CITY OF ALBUQUERQUE

RE: **Lot 3-A, Gillette Addition – 5400 Central Ave. NE**
Grading Plan for Grading Permit & Building Permit

File # **K18-D105**
PE Stamp: 12/16/2013

Based upon the information provided in your submittal received 12-17-2013, the above referenced plan cannot be approved for Grading Permit, Building Permit or SO-19, until the following issues have been addressed:

**LOT 3-A, GILETTE ADDITION
GRADING AND DRAINAGE PLAN**

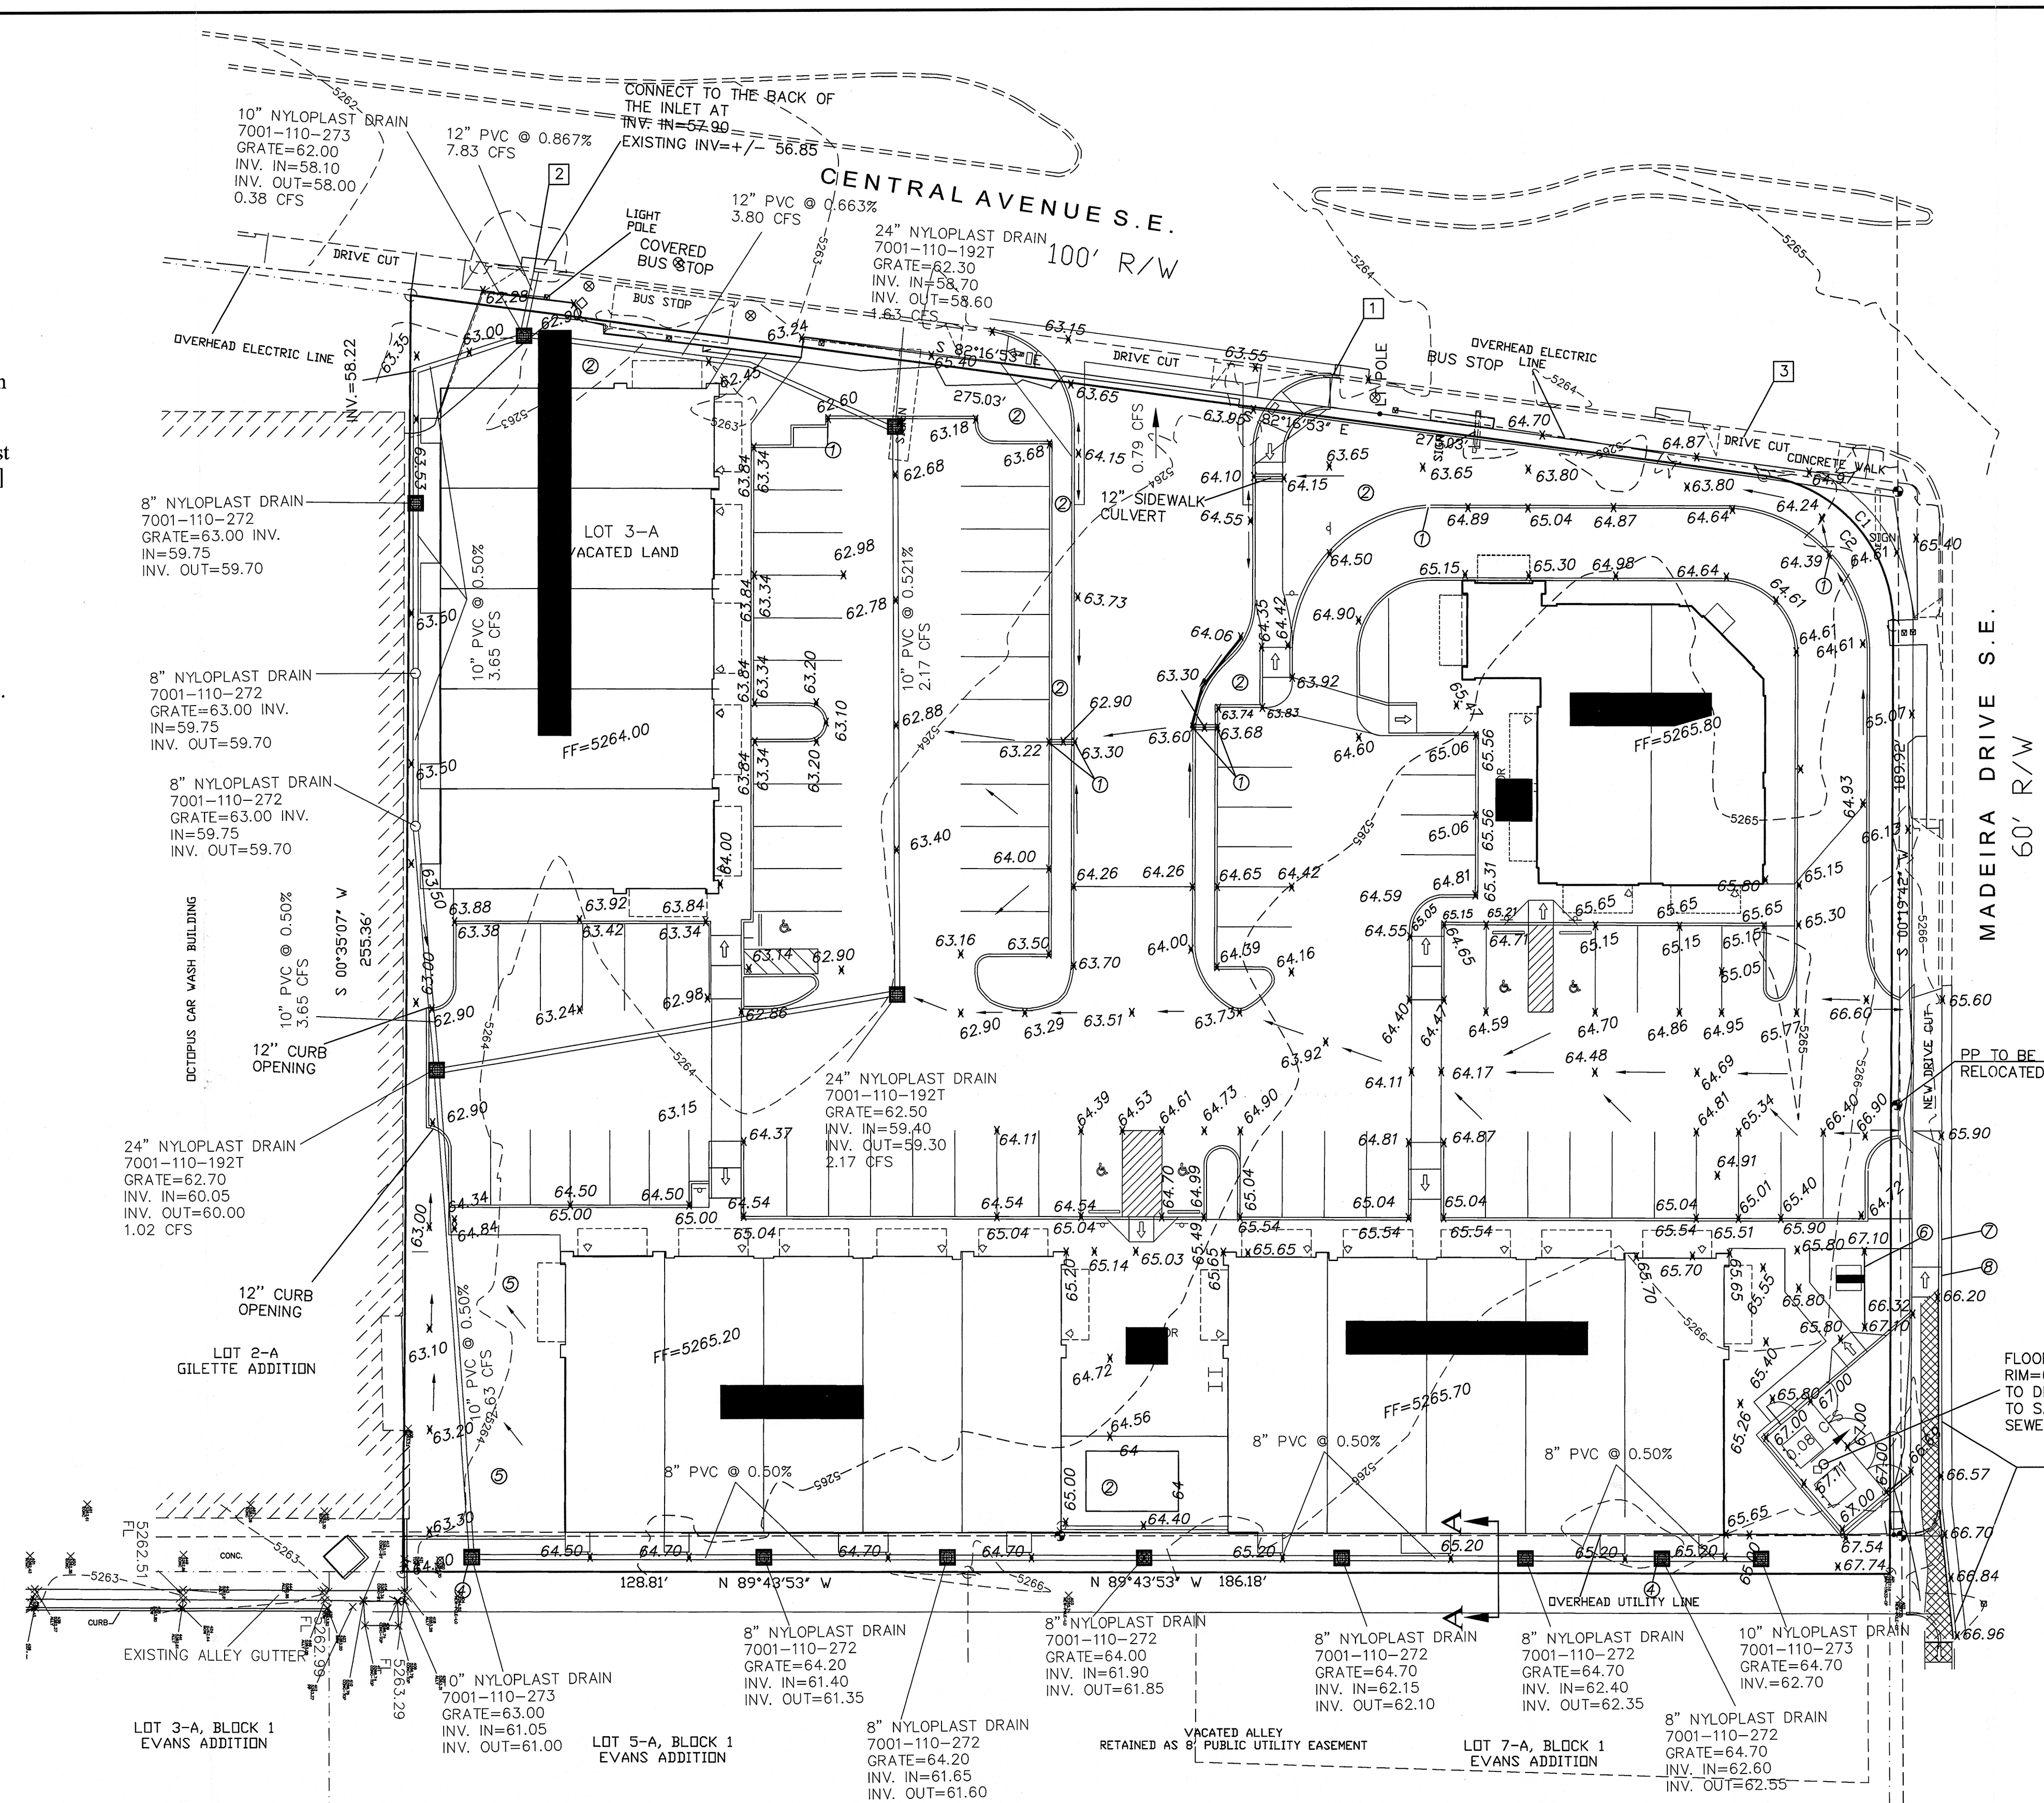
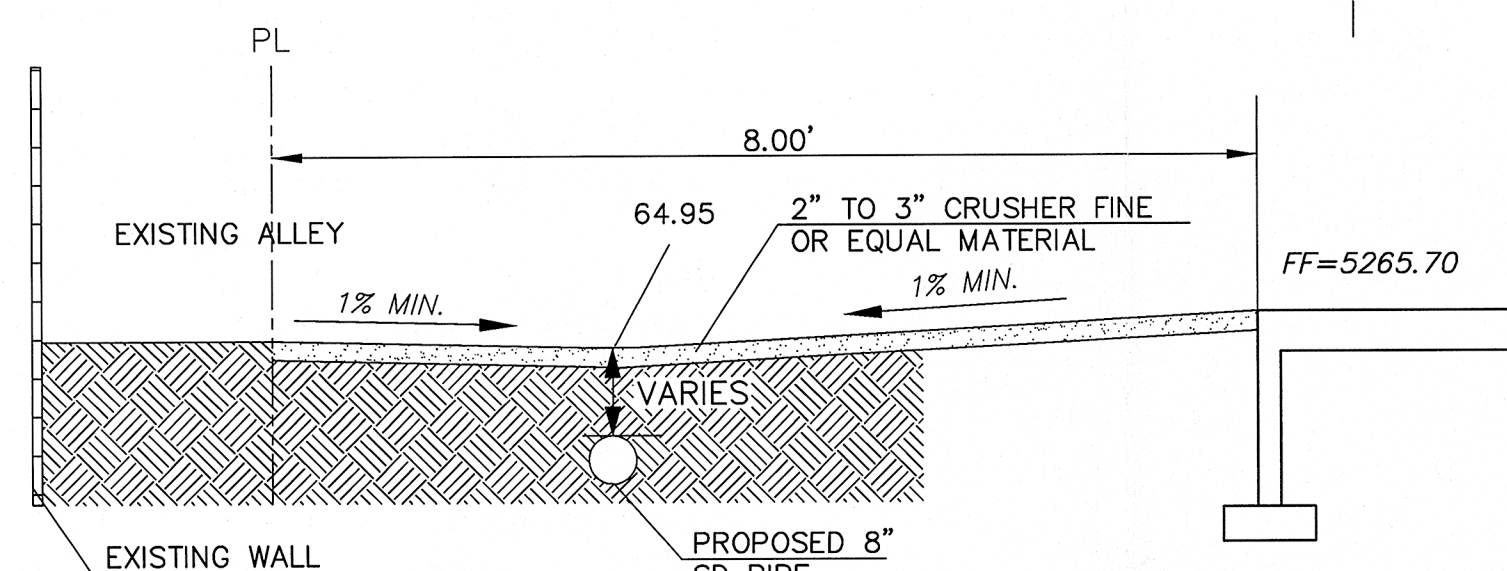
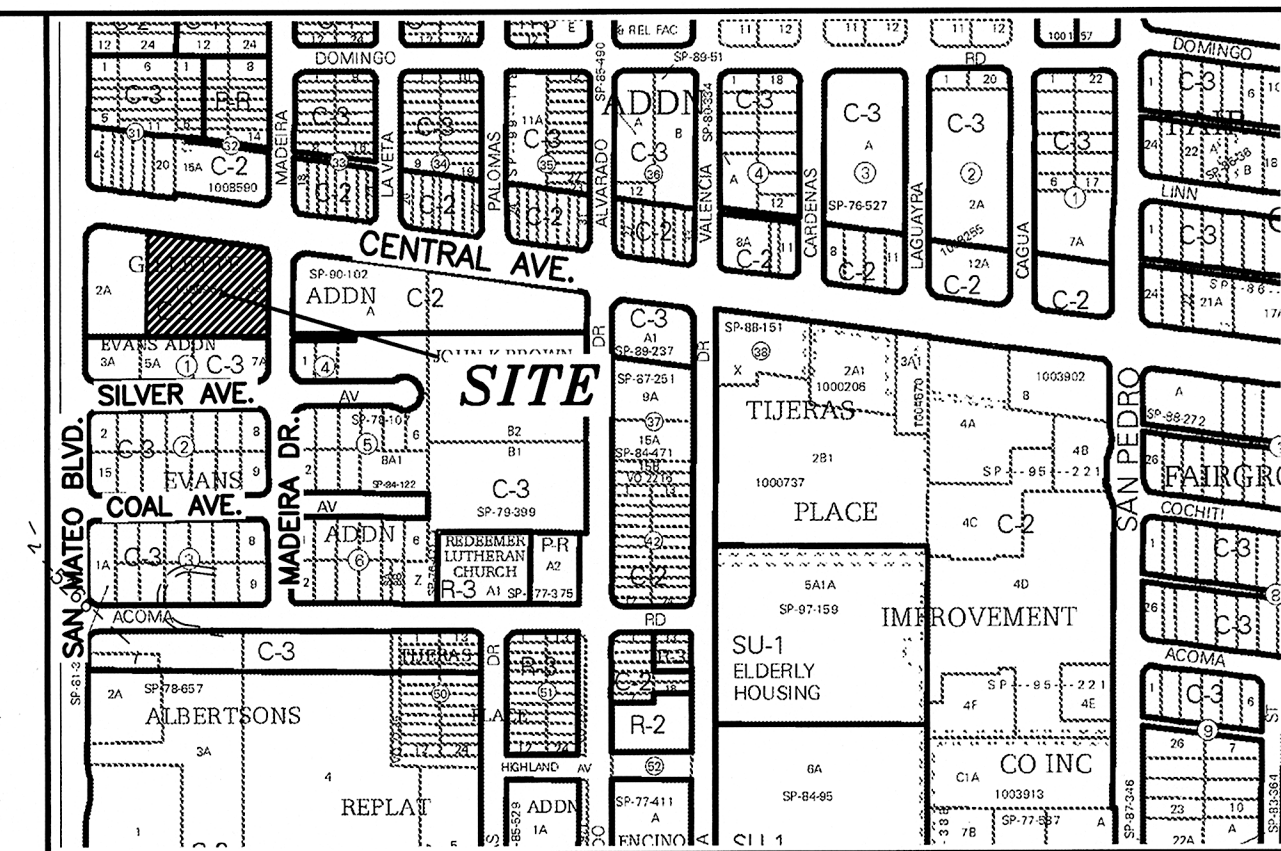
1. The referenced survey monument appears to be in error, since it's 7-miles west of this site. City monument "**5_K18A**" is just east of this site.
2. The site data listed on the plan states an area of only 15,871 sf, however rough calculations indicate this site is over 72,000 sf, or 1.65 acres.

3. Show other details (as discussed with Shawn Biazar, 1/28/14), including installation of rolled curb, drivepads and sidewalks along Madeira, with spot elevations to prevent street flows from entering the vacated alleyway and site.

4. Provide spot elevations or contours at back of sidewalk around the site perimeter.
5. The SO-19 "Notice to Contractors" needs to be updated to refer to the current telephone number for "NM One Call," and provide a signature block for Storm Drain Maintenance to sign-off when inspected.

6. At the SO-19 Storm Drain connection on Central, make reference to the applicable City Standard Drawing 2237. Note that this is a Type Double "C" inlet, and the connection should be toward the west side of the inlet to avoid conflict with the street light base.

7. Historic flows to the west in the vacated alleyway were only about 0.38 cfs (**K18-D071**). The increased flows proposed from the south building roofs will adversely impact the remaining FEMA flood zone on San Mateo. Roof runoff from the proposed buildings on this site should be directed away from the alleyway, to the storm drain connection on Central Ave.

9. The U-shaped concrete swale in the Utility Easement along the south edge of the site is not acceptable, and will conflict with utility access. The diversion of roof flows away from the area will reduce the capacity needed for this section.

11. At the Sidewalk culvert installation on San Mateo, confirm the total width of culvert(s) needed, following diversion of roof flows to Central Ave. Clarify the existing conditions (fence, 4" pipe, curb at back of sidewalk, etc.) at the culvert location. Provide grades to confirm that the culvert will in-fact drain. Extend the sidewalk plate 2-feet behind the back of sidewalk, or provide a curb at back of sidewalk to match the existing curb.

12. The easterly curb return of the north entry to Central appears to butt up to an existing Storm Drain Inlet. Add a note for the contractor to construct the gutter section to match the inlet, gutter transition design, Std. Dwg. 2207, modified to begin the PT of the return at the west edge of the inlet. The 3'-0" taper, with 2 3/4" back slope to the grate and expansion joint are required. The dowel bars between the west inlet wall and the new transition gutter must be maintained, as shown on Dwg. 2205.

13. If the existing drivepad encroachment at the NW corner of the site is removed and rebuilt with a radius, notes similar to those in item 12 may apply to the inlet there.

17. Provide some specific notes, spot elevations, flow arrows, and details to depress some of the landscape areas for water harvesting.
